Ref: 6/2019/2952/HOUSE  
Date: 11/12/2019

## HISTORIC BUILDINGS AND CONSERVATION ADVICE

**RE: *Just House, Coopers Lane, Northaw, Potters Bar, EN6 4NJ***

The application is for the erection of a replacement of existing timber fence with new 2m high timber fence. This follows the refusal of an application for the erection of new gates and railings (6/2019/2165/HOUSE).

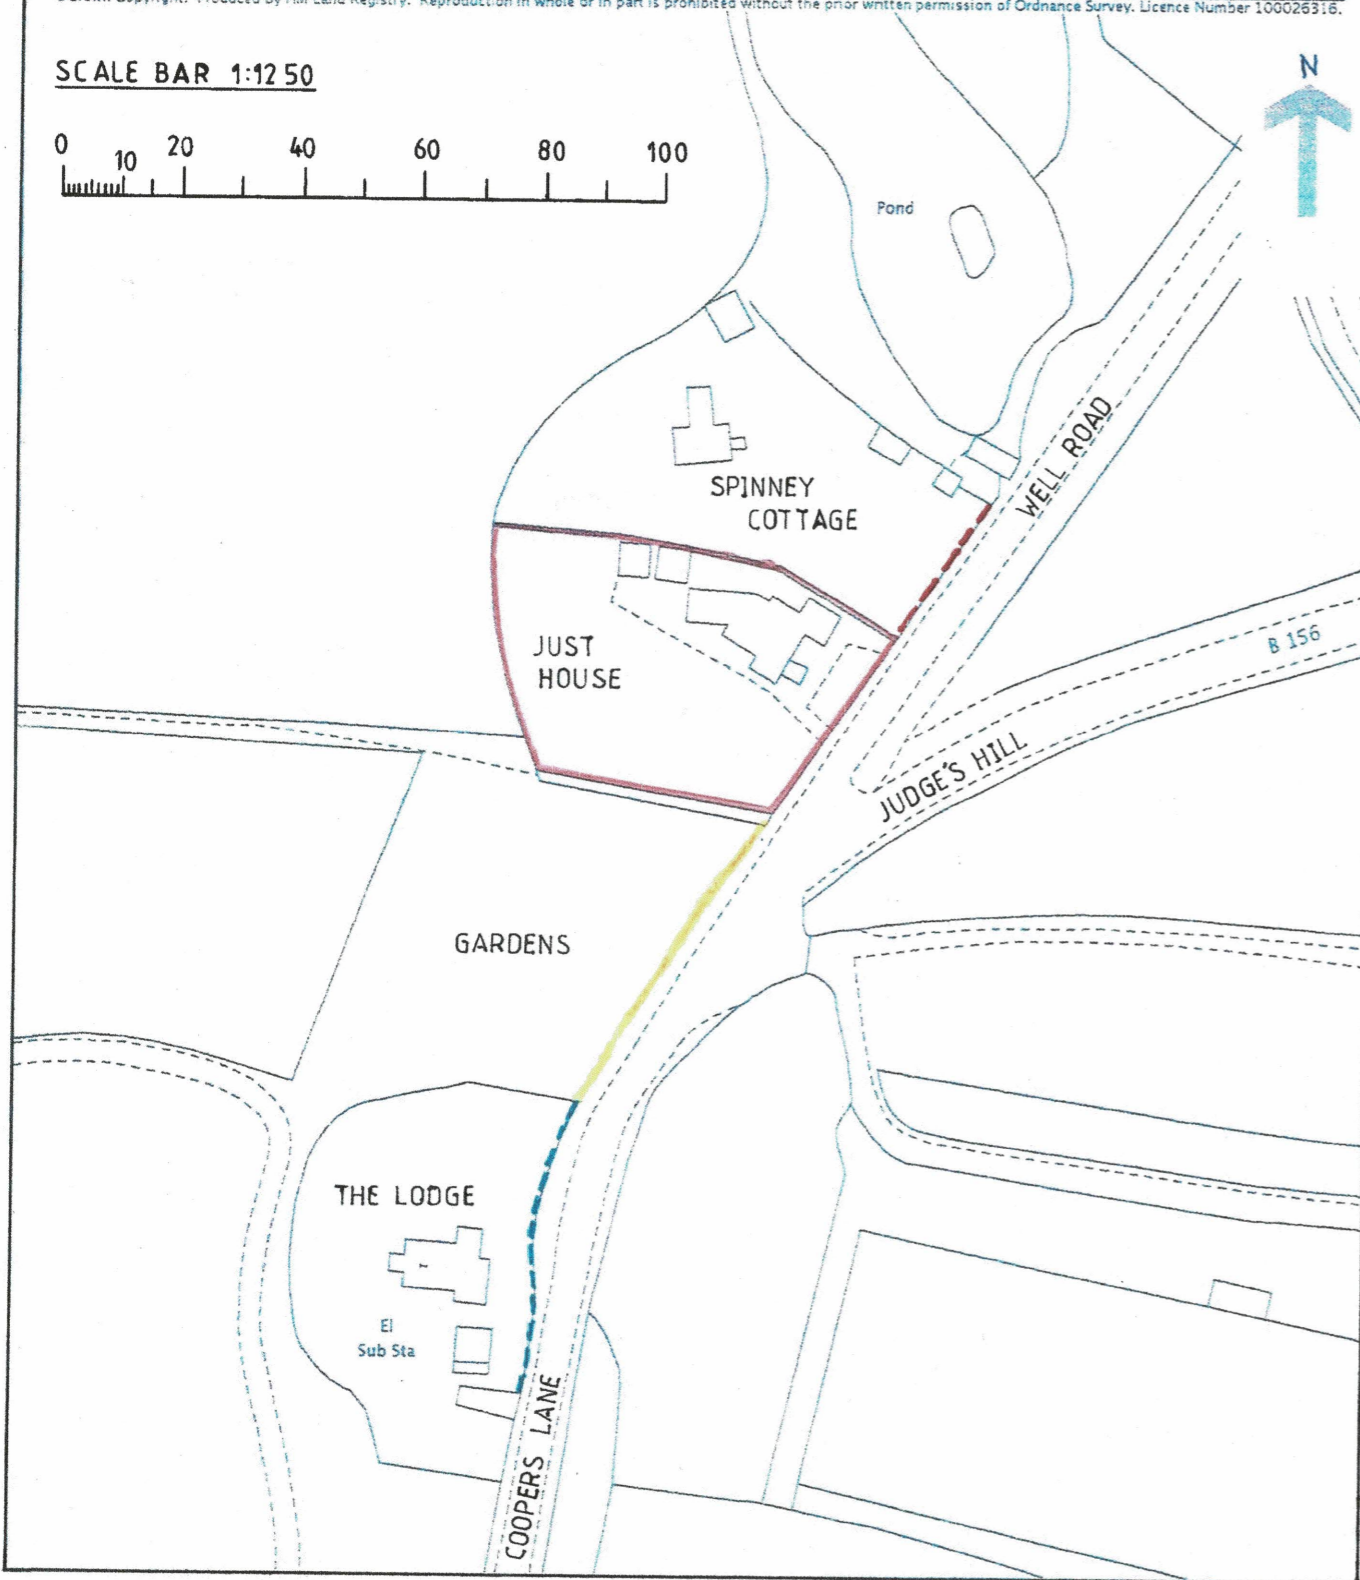
The proposed 2 metre high close boarded fence is a more solid boundary treatment than the existing picket fence and slightly detracts from the rural character of the road. The impact of the proposed fence could be lessened through a slight reduction in height and by planting which would soften its blank frontage along the road. The property already benefits from a mature hedge/planting along its boundary, but this is not shown on the proposed drawings. It is vital that this is retained and supplemented where gaps have developed.

If it is confirmed that the existing hedge will be retained and supplemented where necessary, then there would be no objections to the proposal. A slight reduction in height would also be beneficial. If
